Comments for Planning Application 20/00909/HOU

Application Number: 20/00909/HOU

Address: 84 Hartley Road Portsmouth PO2 9HX

Proposal: Single storey flat roof rear extension

Proposed Layout Extension, Alterations & Improvements

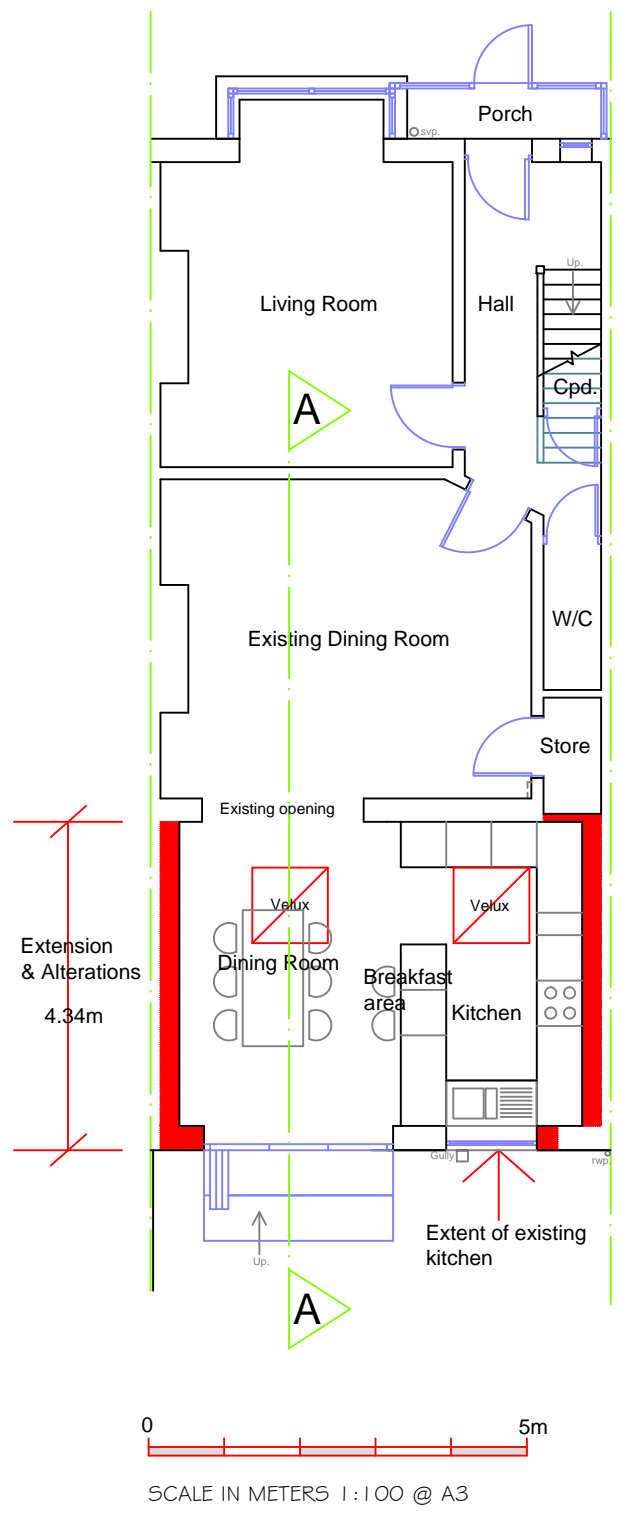
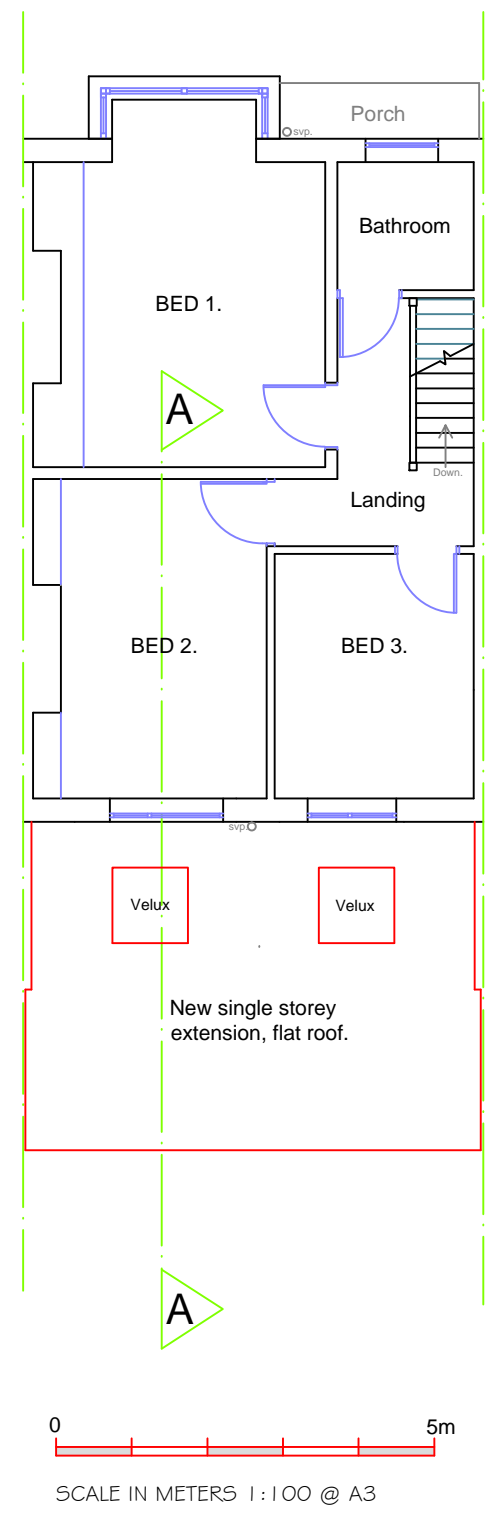
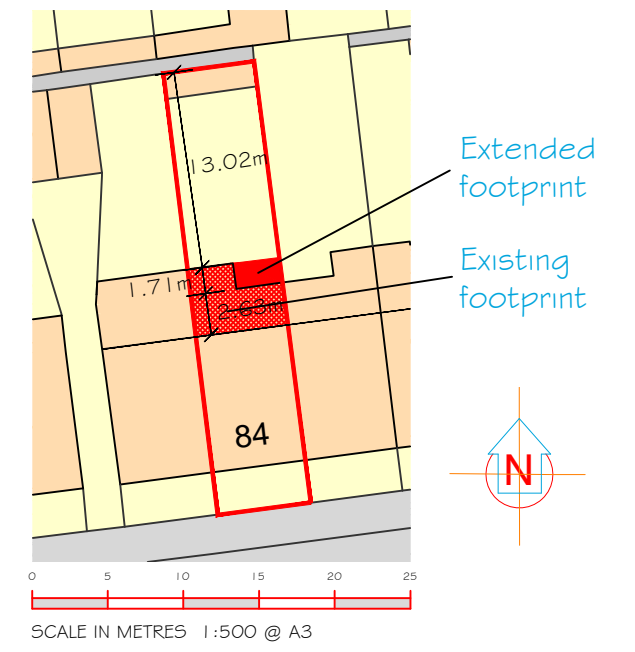
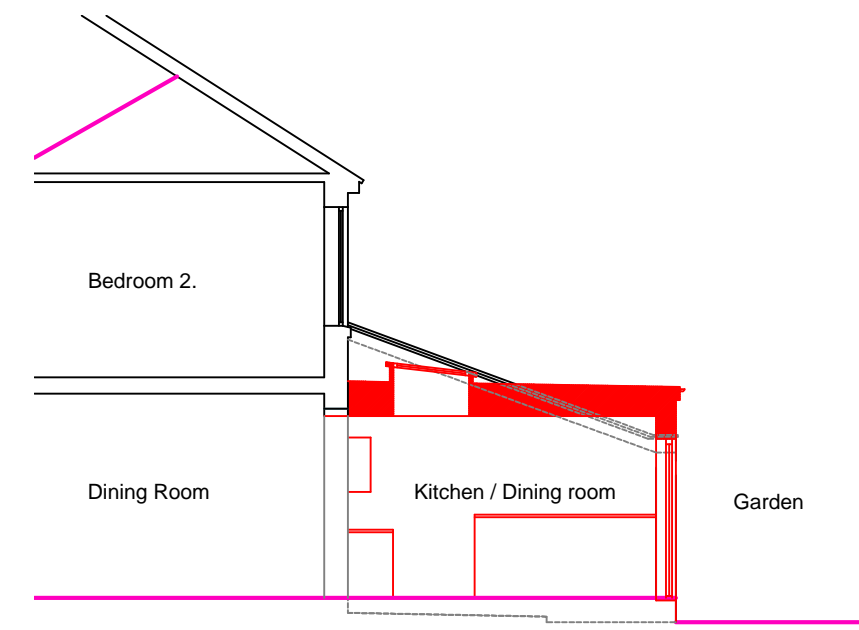
Comment: I'm in support as long as there is no alteration to the pitch and height of the existing party wall/fire wall. All amendments to the existing height and pitch to be constructed on the proposers/neighbours side off the wall.
